Your ref:	Eyre Court	<b>Please reply to:</b>	<b>Rayhan Ali</b>
Our ref:	23/07025/FULL	Tel No:	07866033247
		Fee Queries:	0207 641 6500;
		Email:	planningreception@westminster.gov.uk;
Mr Gregory Mc Kinney Opsis Design 18, 71H Drayton Park, London N5 1DU		<b>Incomplete Applications</b> Town Planning & Building Control City of Westminster PO Box 732 Redhill, RH1 9FL	
		3 November 2023

**Address: Flat 20, Eyre Court, 3-21 Finchley Road, London, NW8 9TT,**

**Proposal: Installation of replacement windows including inseration of three Extractor fan at North Elevation.**

DWG.#:
PL-PR-01

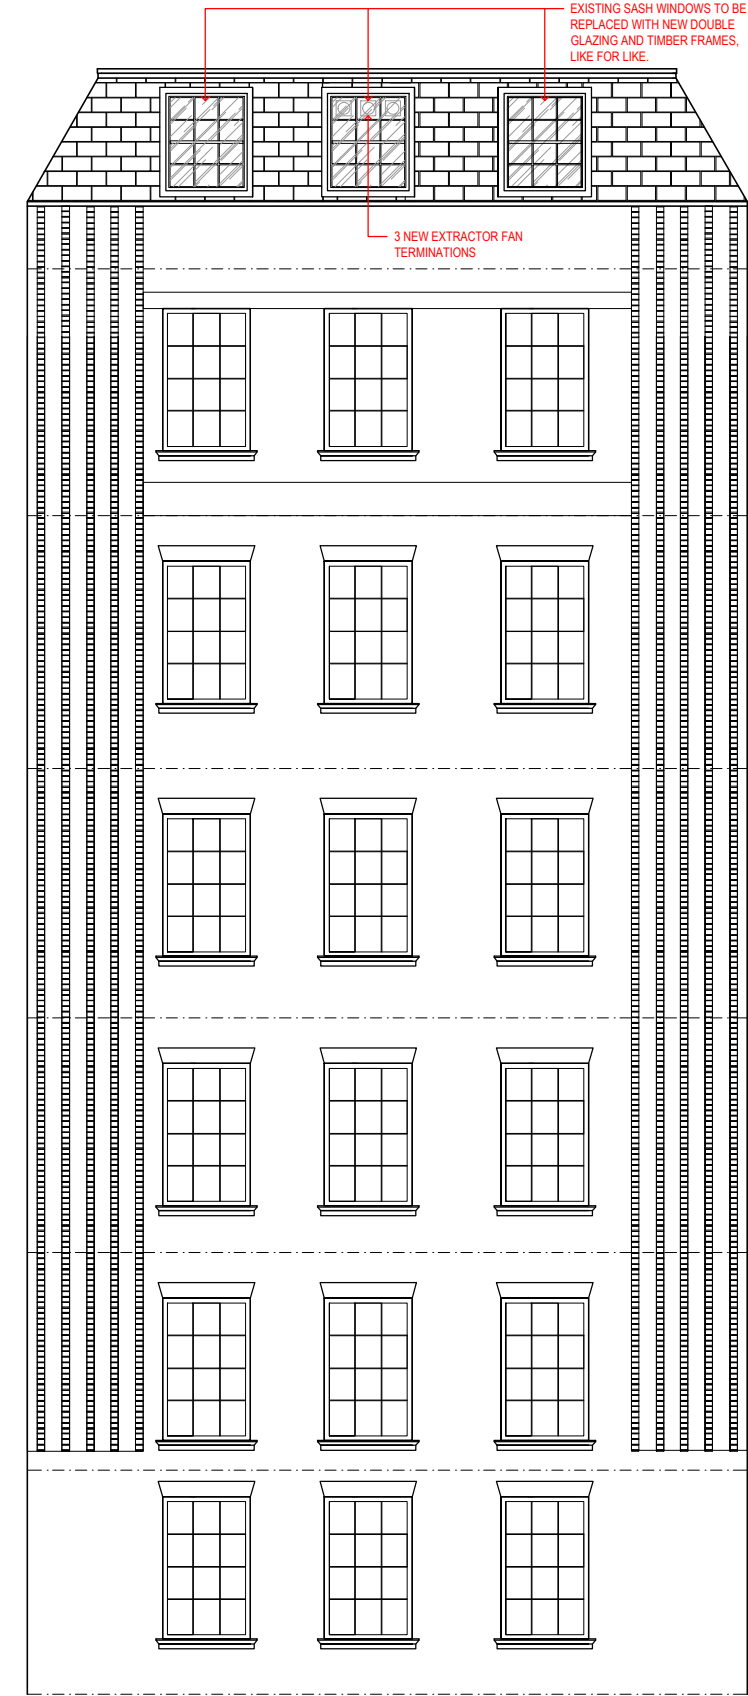
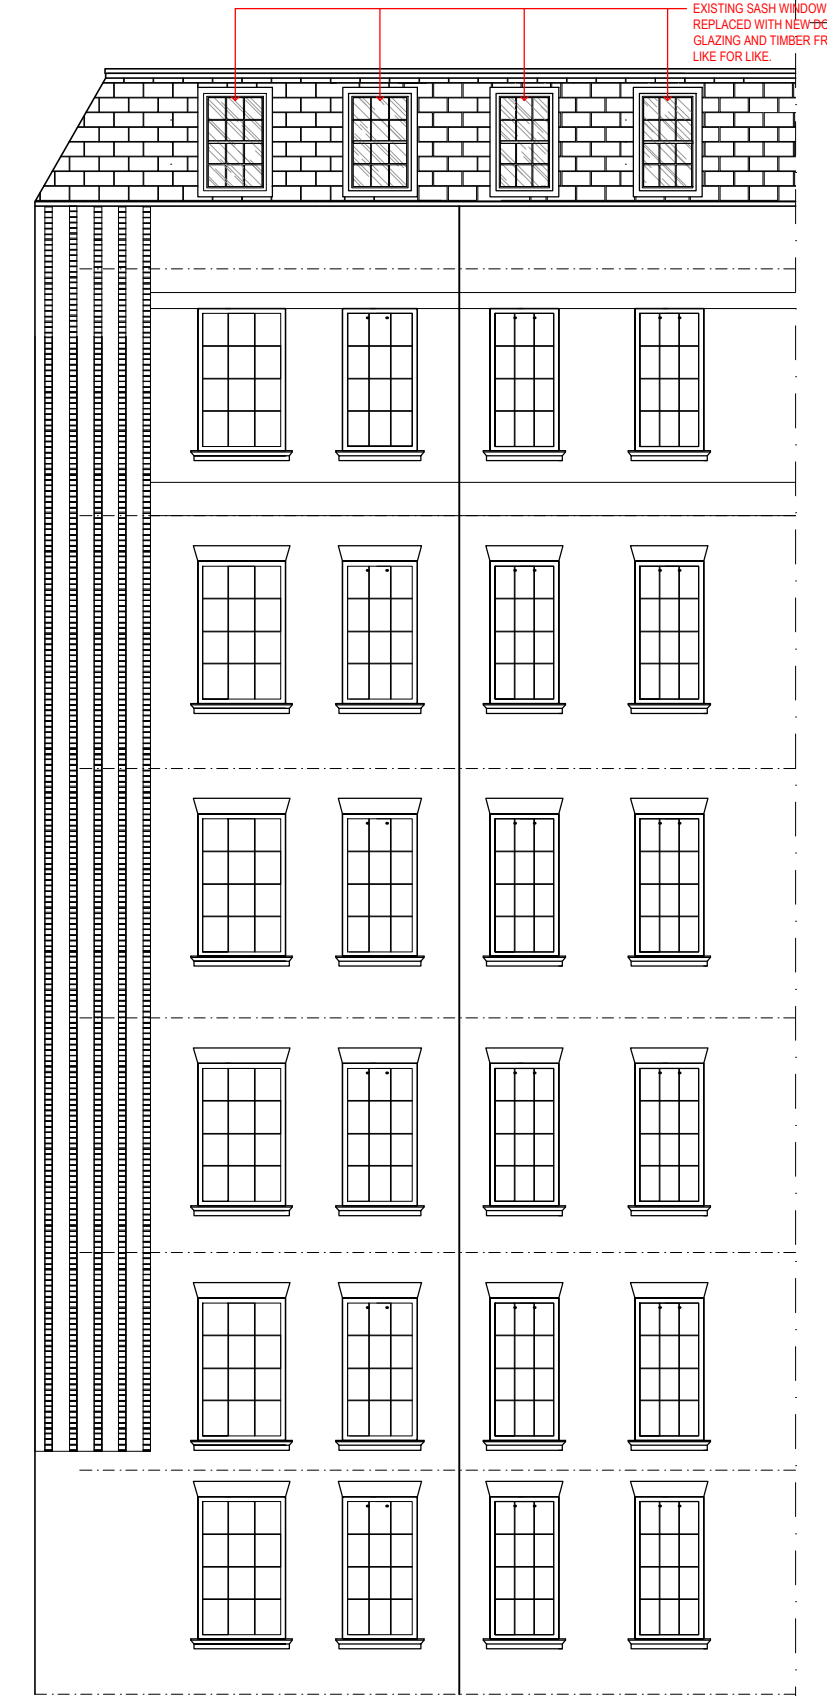
- 3 Please provide Proposed floor plan (to correspond with the submitted Existing floor plan)
  - 4 Your drawings show you are proposing for three extractor fans, if they are mechanically operated then please provide a noise report.
- 0 \*Please collate all requested information in a single submission and send to [planningreception@westminster.gov.uk](mailto:planningreception@westminster.gov.uk). Sending your documents individually will not speed up the process. Please do not upload to the planning portal as this causes duplication and may delay the processing of your application. Thank you.\*
